**From:** Maria Tomalova <[Maria.Tomalova@arun.gov.uk](mailto:Maria.Tomalova@arun.gov.uk)>  
**Sent:** 22 September 2020 08:31  
**To:** Planning.Responses <[Planning.Responses@arun.gov.uk](mailto:Planning.Responses@arun.gov.uk)>  
**Subject:** FW: FW: BR/188/20/DOC -

Please upload the below to the above application: Drainage Engineers comments.

**From:** Laura Gibbons [REDACTED]  
**Sent:** 15 September 2020 09:58  
**To:** Elvin Gomery [REDACTED]  
**Cc:** Maria Tomalova <[Maria.Tomalova@arun.gov.uk](mailto:Maria.Tomalova@arun.gov.uk)>; Stuart Bone [REDACTED]  
**Subject:** Re: FW: BR/188/20/DOC -

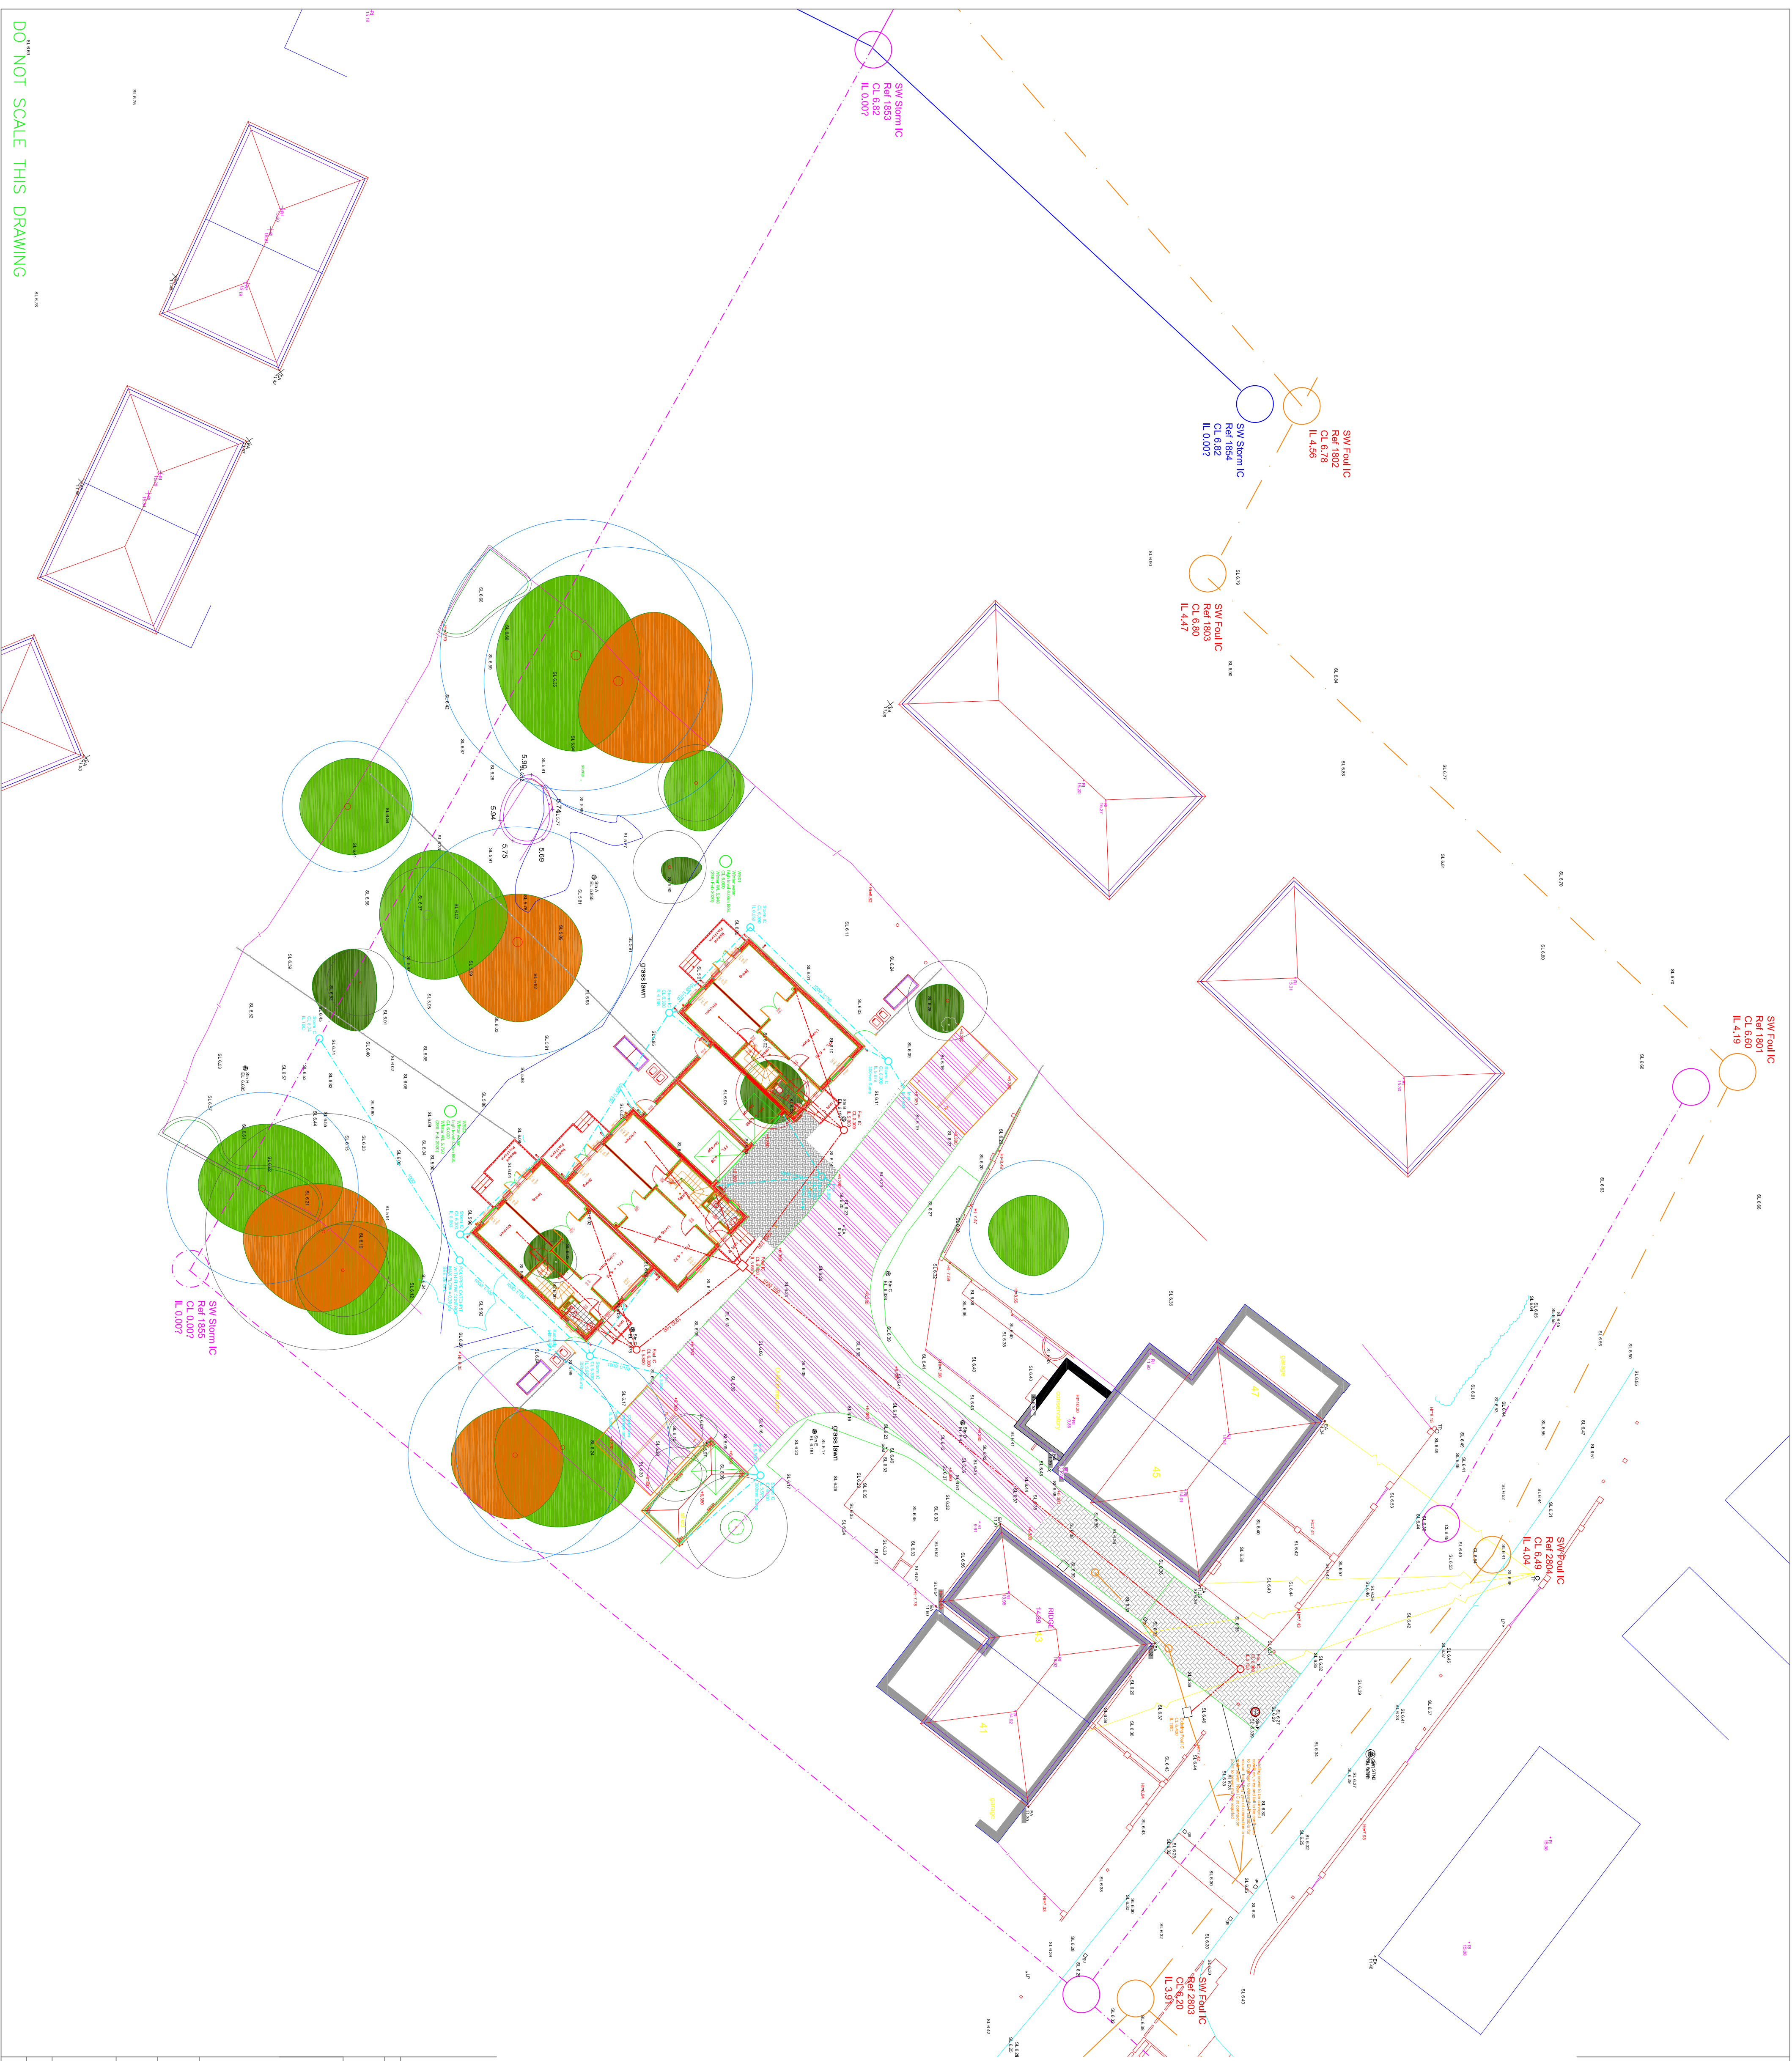
Please can you send over detailed network calculations as previously requested.

Permeable paving to the parking area must be provided to allow water to flow through the carport area. It was established with Robert Clark that without this flooding could be increased off site. We do not wish to see water flowing under the habitable accommodation itself.

As your last email please find attached our updated drawing showing permeable construction within the car port areas.
